RE: The Grove PUD
Attn: Kittitas County Planning Commission

Thank you for extending the written public comment period on The Grove PUD application, following your July 25 meeting. There were several points that arose during that meeting that we wish to address. In particular, there are several assumptions in the Traffic Impact Analysis for The Grove that are highly questionable, leading to an understatement of transportation impacts from the complex.

The Traffic Impact Analysis (TIA) performed by Sunburst Engineering includes several dubious or misinformed assumptions, leading to a significant understatement of the likely transportation impacts from Grove residents.

Figure 3
 Distribution Map

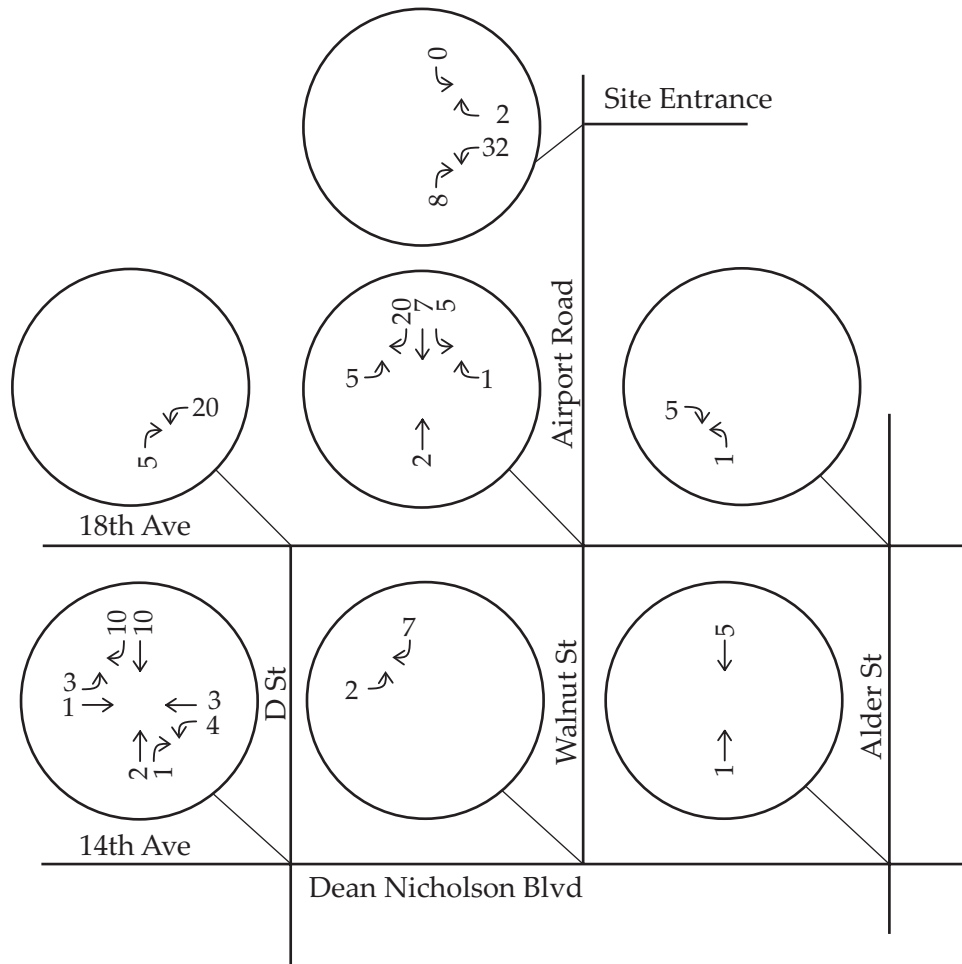
- The TIA assumes that, after driving south to the intersection of “D” Street and 14th Street, a “nearly identical” number of vehicles continued west on 14th St. and south on “D” Street. This is a deeply flawed assumption; a preponderance of the traffic continues south along “D” Street.
